Application No: H19-0584-19 **Applicant:** Mr M Bacon

Proposal: Details of external materials, landscaping, doors, windows and roof lights, archaeological report (Conditions 4, 6, 7, 8, 10, 15 and 17 of H19-0757-18)

Location: North Of The Oaks 251 Broadgate Road Sutton St Edmund

PROPOSED SITE PLAN 1:200

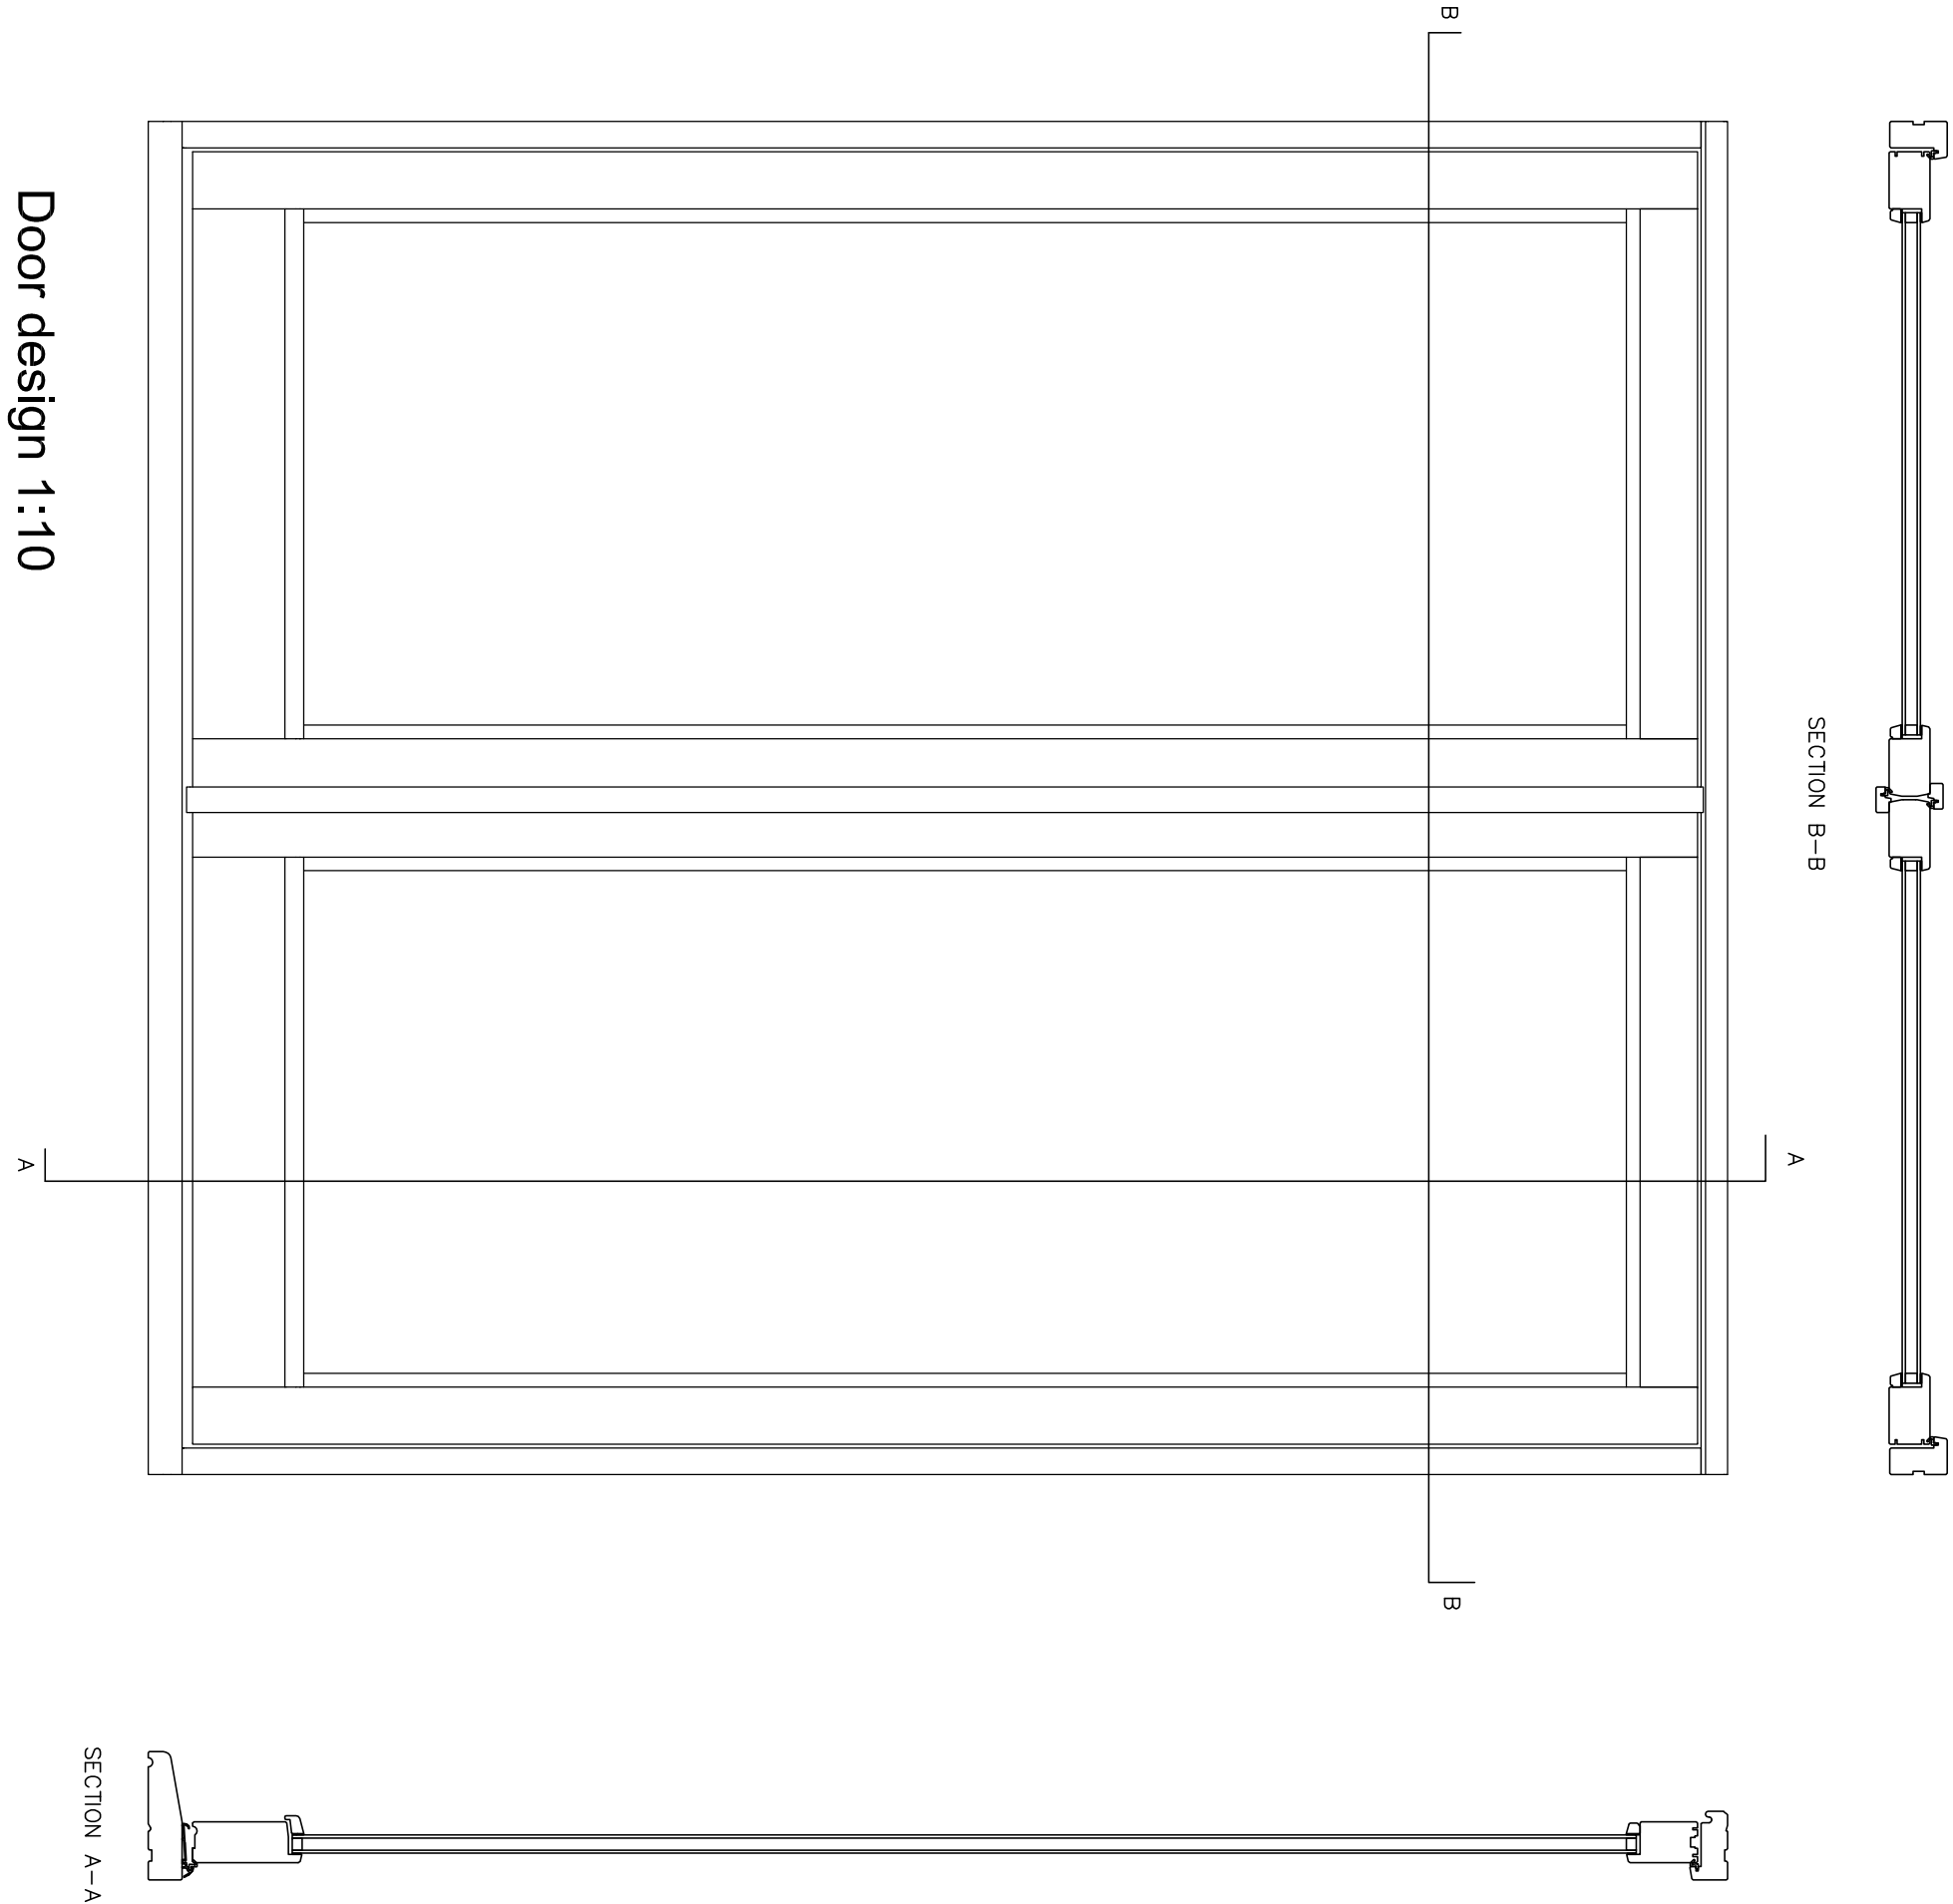
Condition 6 (Landscaping) - The scheme includes Silver Birch, Cherry and Whitebeam, plus shrubs and ground cover plants. It is considered to be acceptable.

DRAWING TITLE
BARN 1 - REBUILD

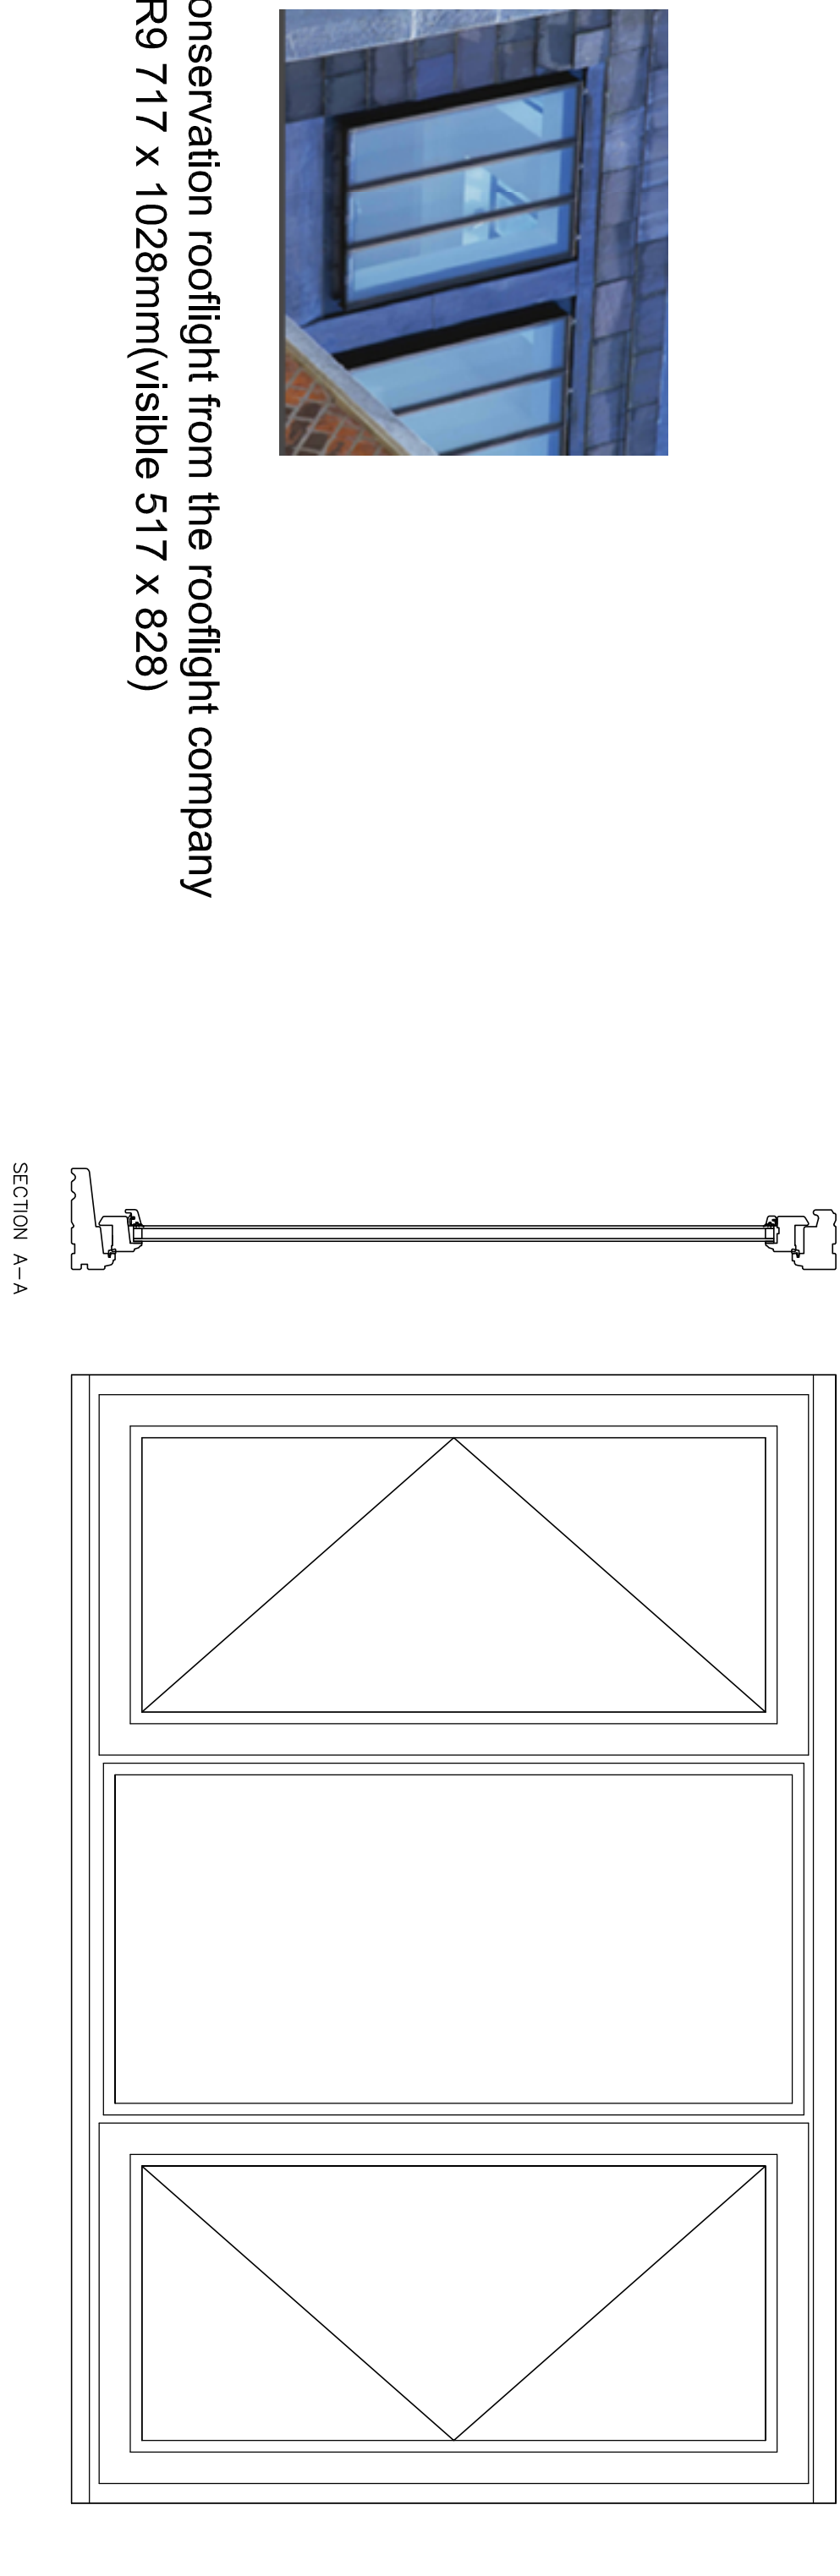
Condition 8 (Windows) - The submitted details are acceptable. The windows would be constructed in timber and stained dark brown as per condition 9.
